RE: DRAINAGE PLAN FOR CASA FELICITA APARTMENTS (J-14/D61)  
RECEIVED APRIL 9, 1986

A preliminary review of your submittal for Building Permit approval has shown that the following information is lacking for this section to begin the review process:

DRAINAGE PLAN
 PARCEL 14 MARTINEZTOWN NEIGHBORHOOD DEVELOPME
 ALBUQUERQUE, NEW MEXICO
 FLOOD MAP 28, BENCHMARK 5-J15, ELEV. 4967.34 SOIL 7
 TOTAL AREA 26,562 SQ. FT. - 0.61 ACRES
 TOTAL AREA ROOFED OR PAVED: 6036 SQ. FT. - 23% - EX.
 AND 11,072 SQ. FT. - 42% PROPOSED
 FILE # J14/DGI APPROVED

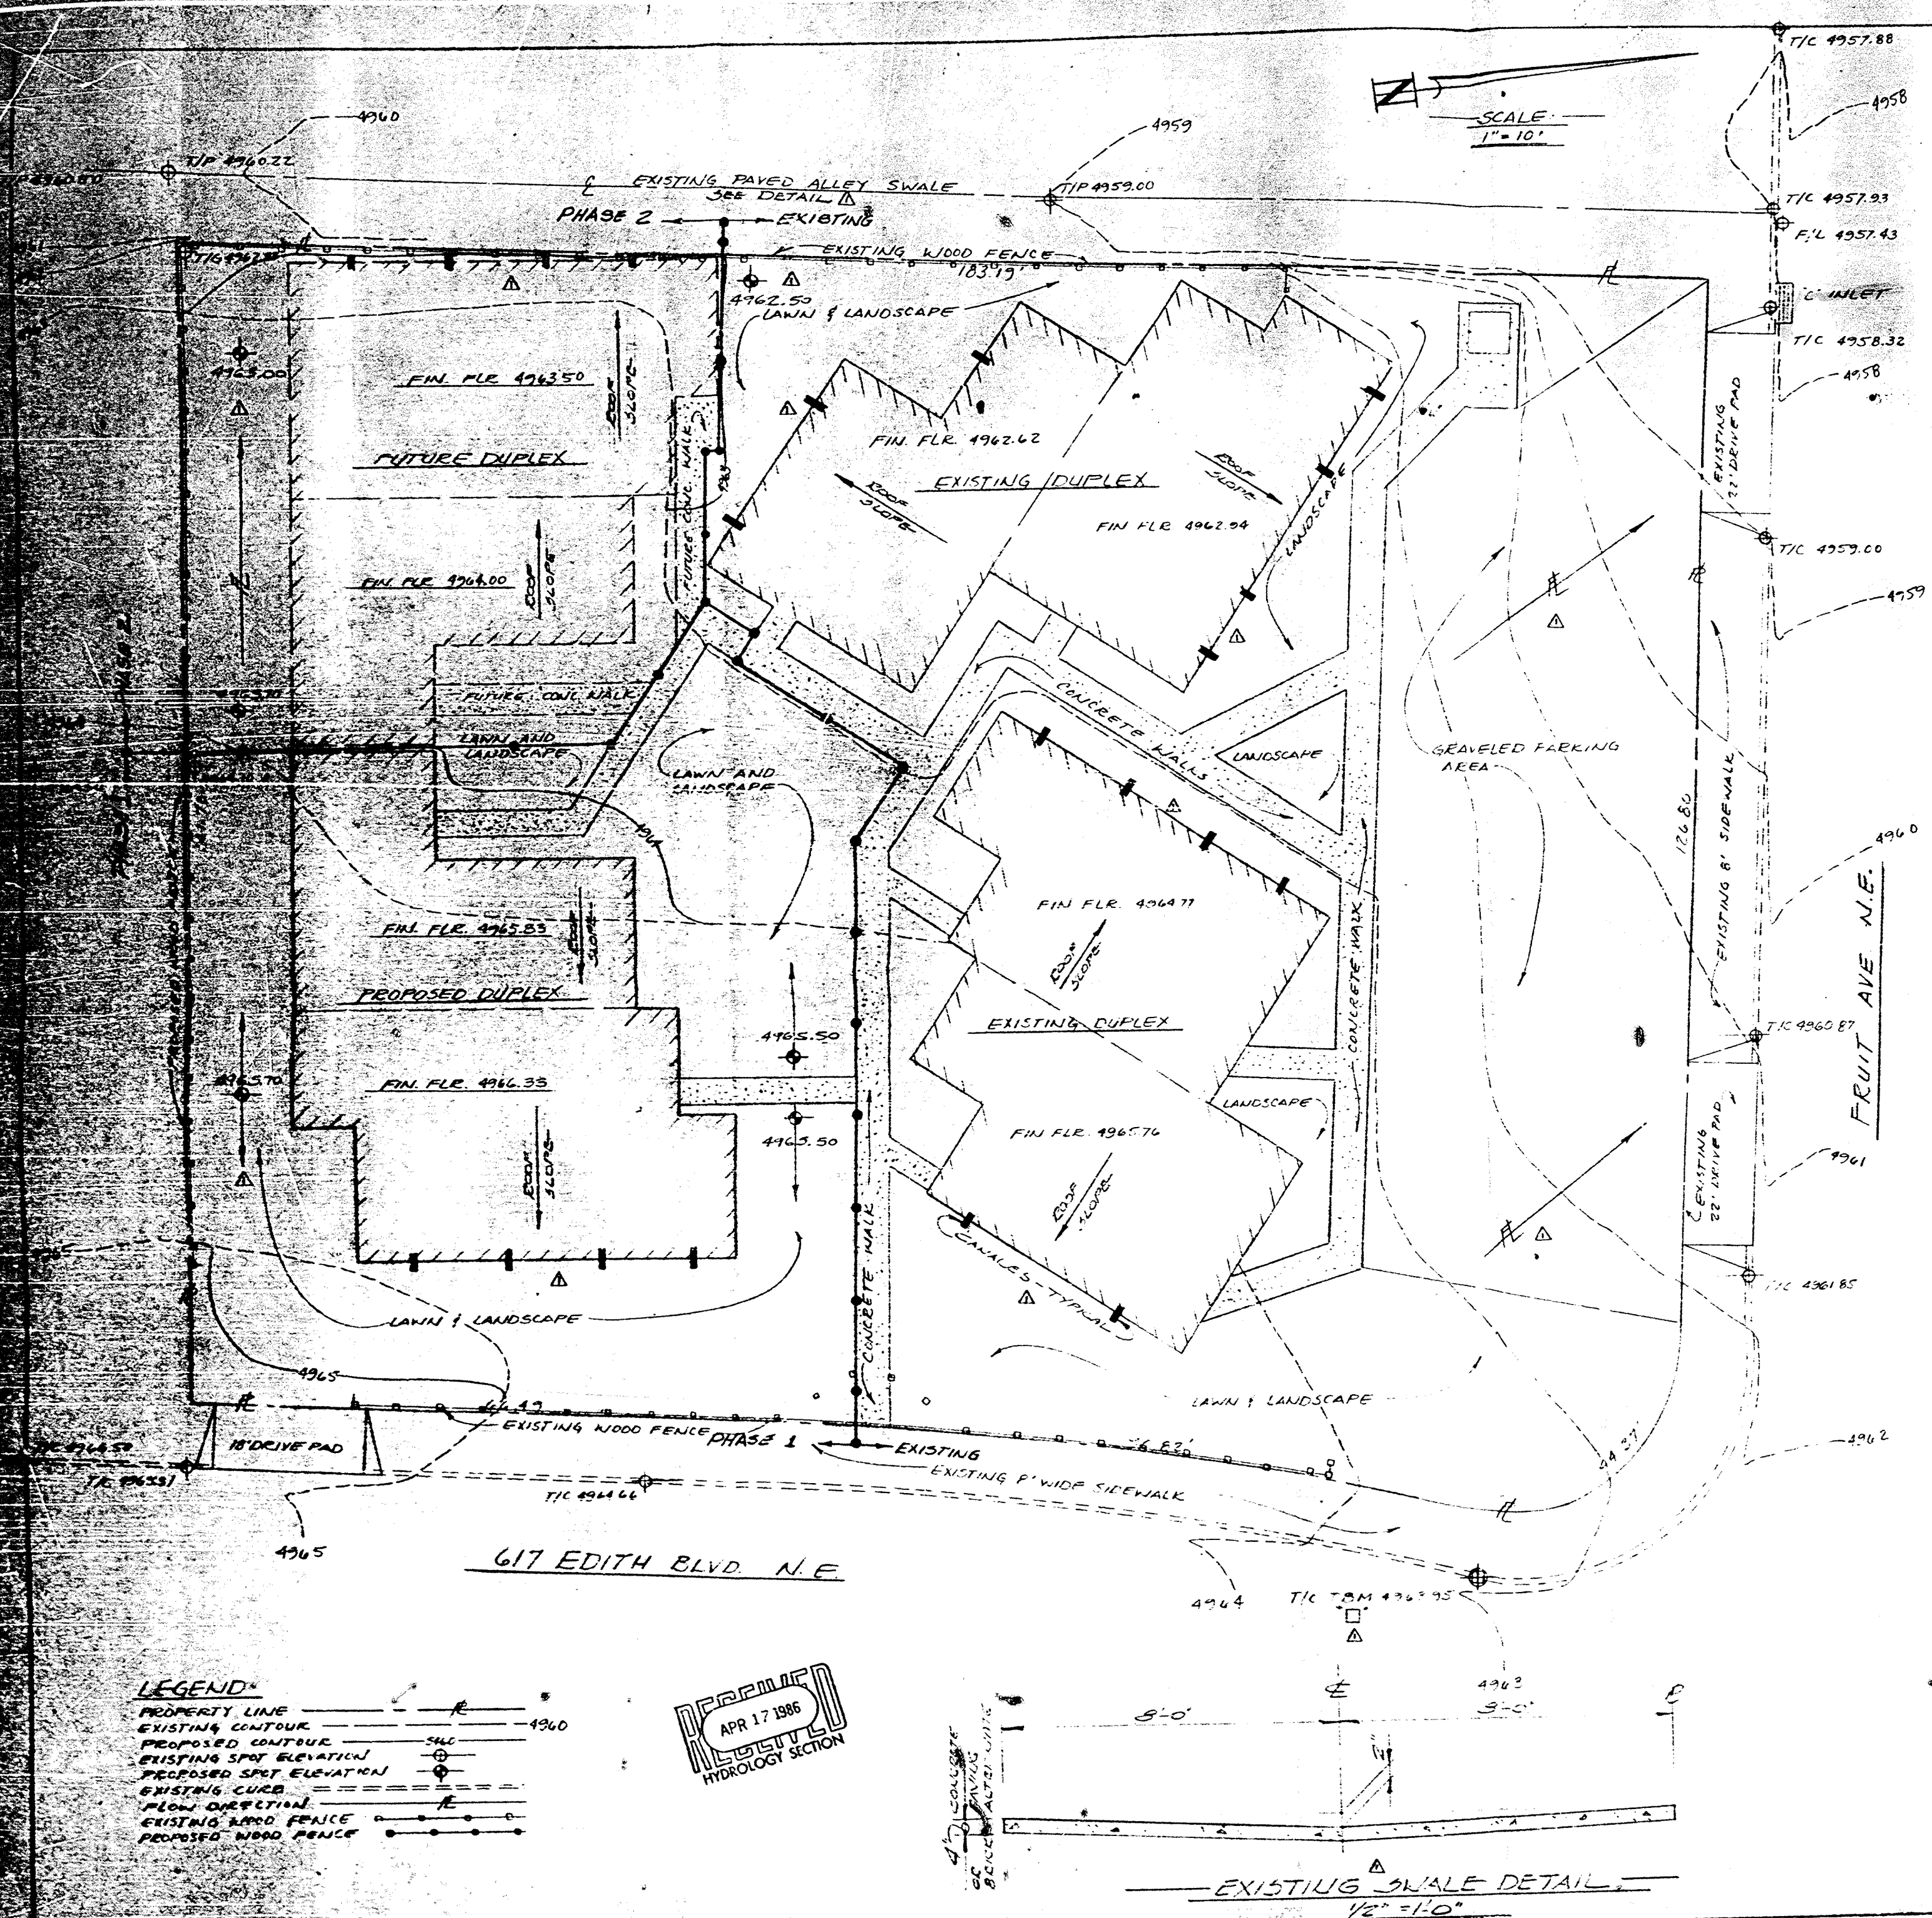
1. Location of B.M., TBM must be identified as a curb notch or painted.
2. Location and direction of roof drains.
3. More spot elevations to show where developed run-off is supposed to go.
4. Swale detail.
5. Please identify what methods the contractor might use to control erosion.
